CITY OF ALBUQUERQUE

July 26, 2017

**RE: Sawmill Village Phase 2
Grading Plan
Stamp Date: 7/24/17
Hydrology File: H13D025A C**

Based upon the information provided in your submittal received 7/24/17, the Grading Plan is **not** approved for Building Permit. The following comments need to be addressed for approval of the above referenced project:

GRADING PLAN

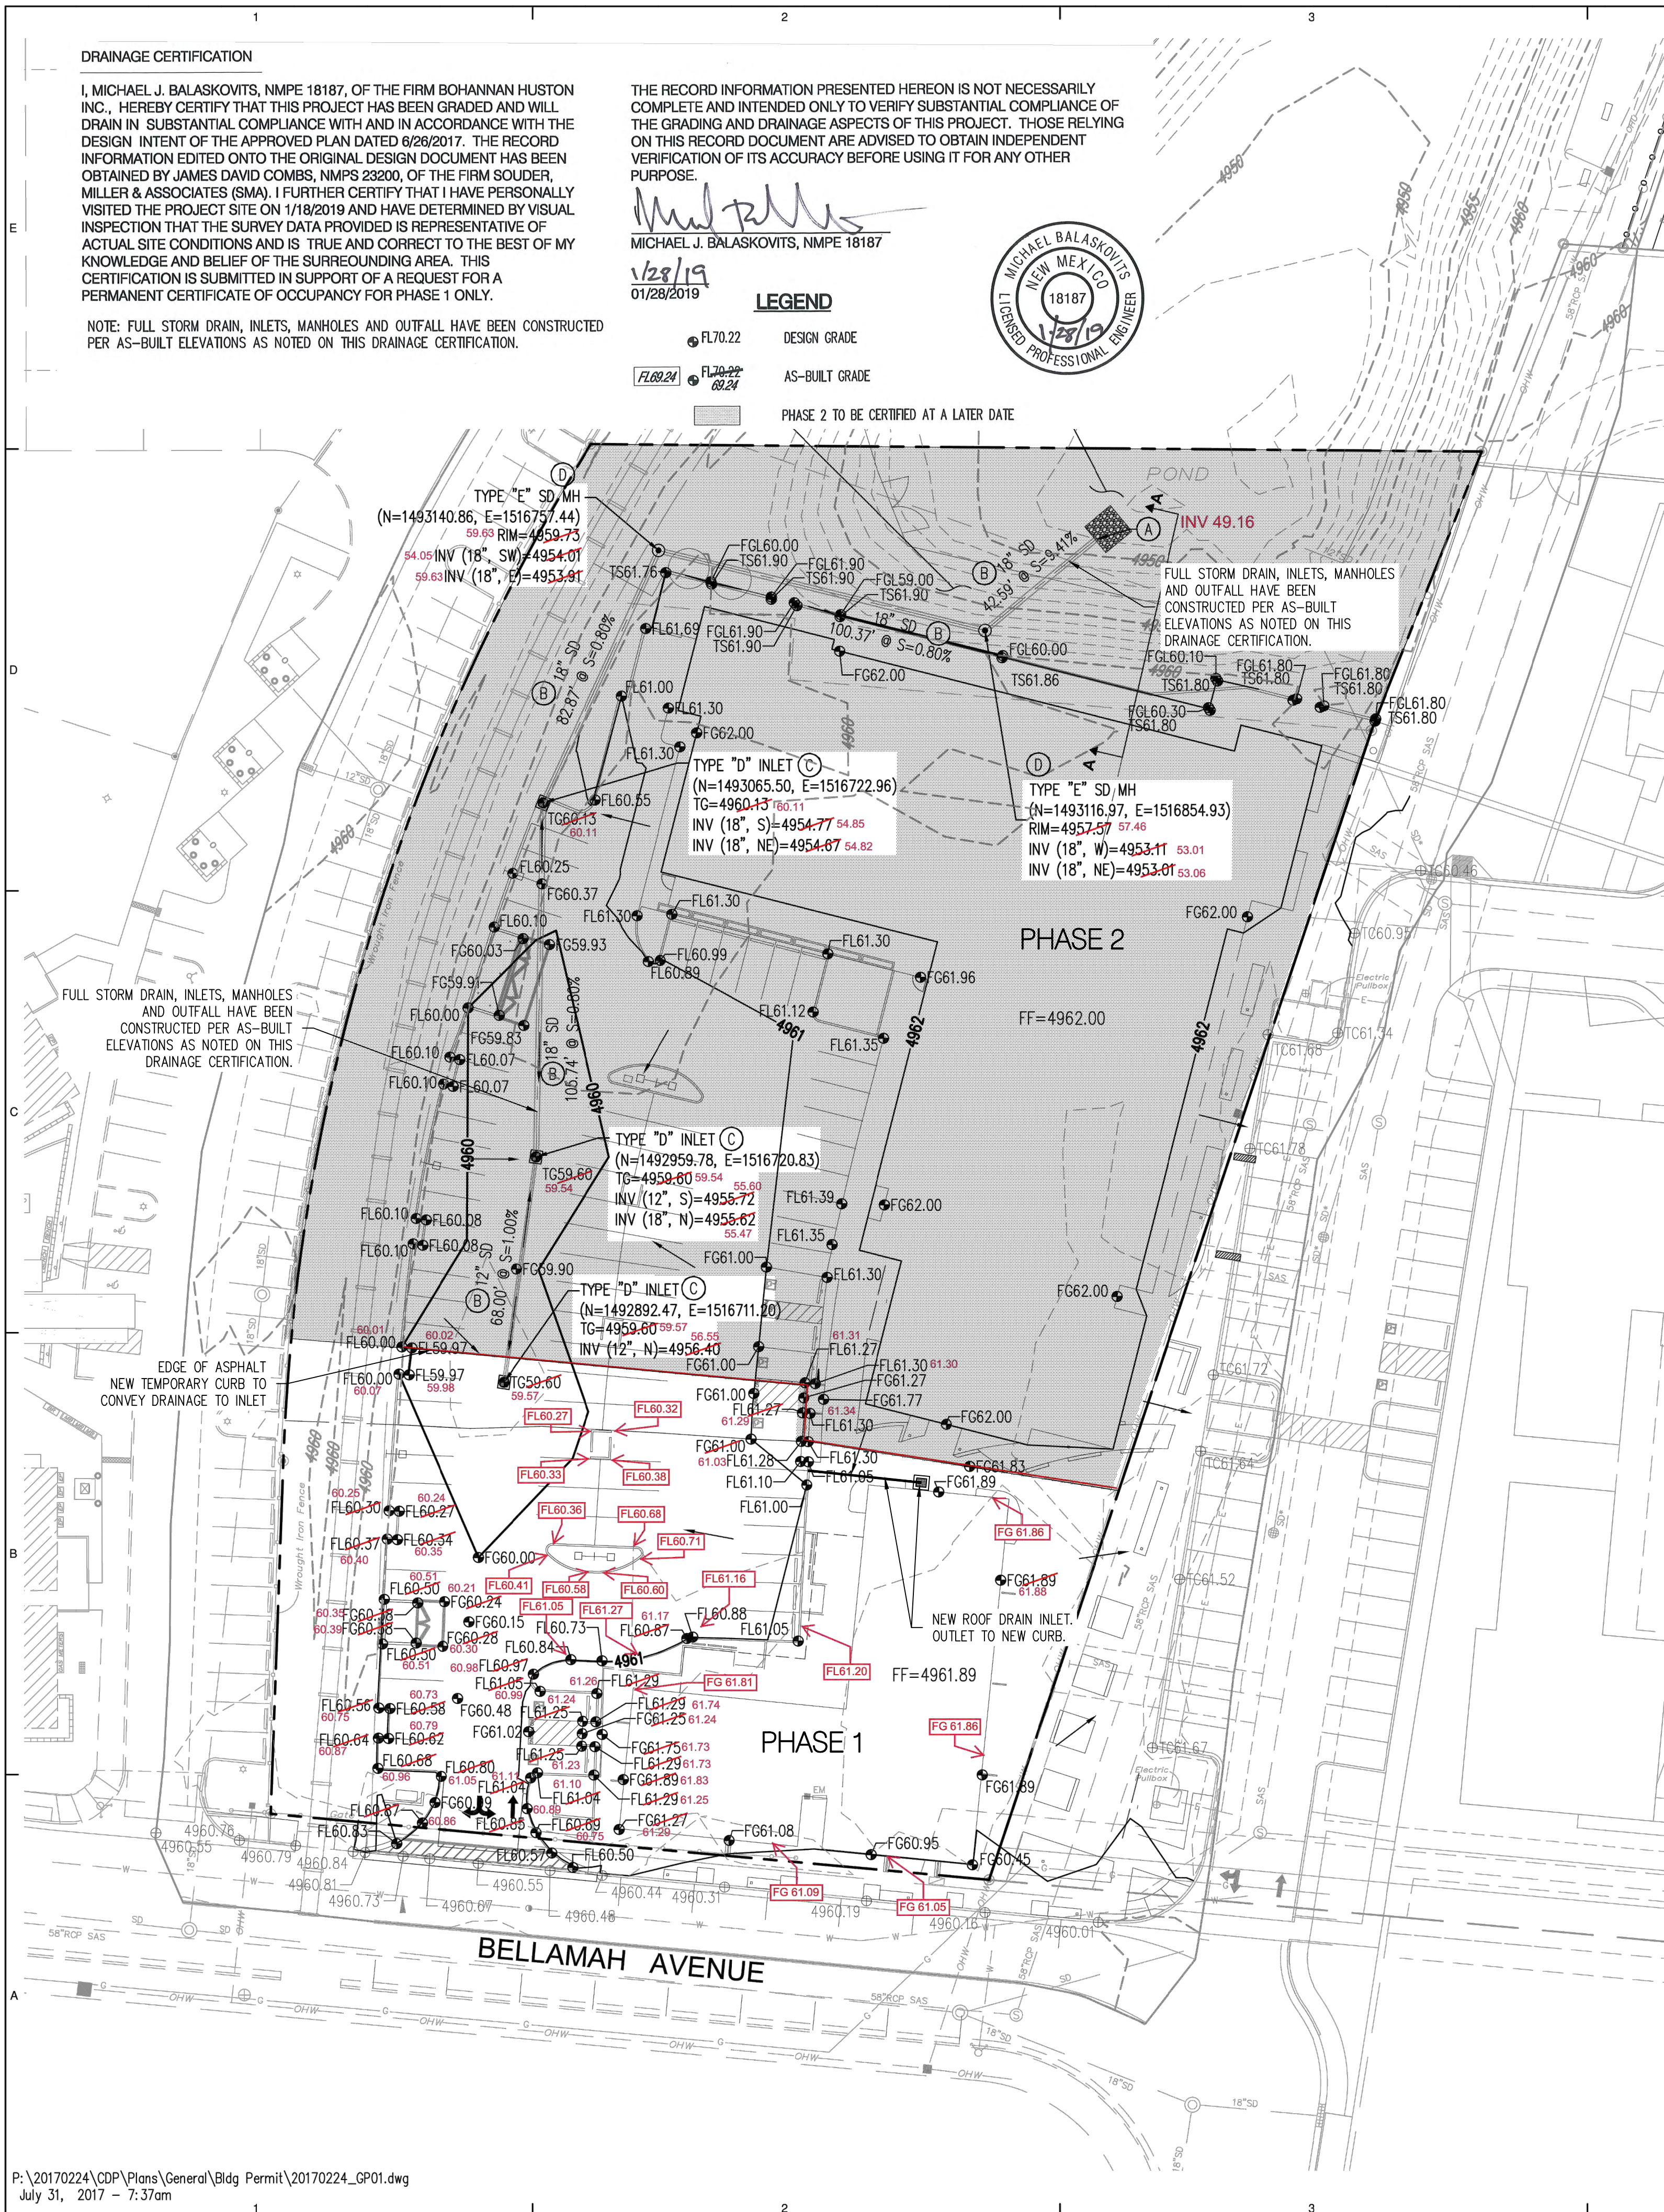
1. Please provide the required 0.87' water block per COA Paving Detail No. 2426.
2. Please provide the three point chart for each driveway radius per COA Paving Detail No. 2426.
3. Please provide a section through the proposed building and existing adjacent pond. Please label the elevations of the top of pond, the bottom of pond and the 100 year WSE.
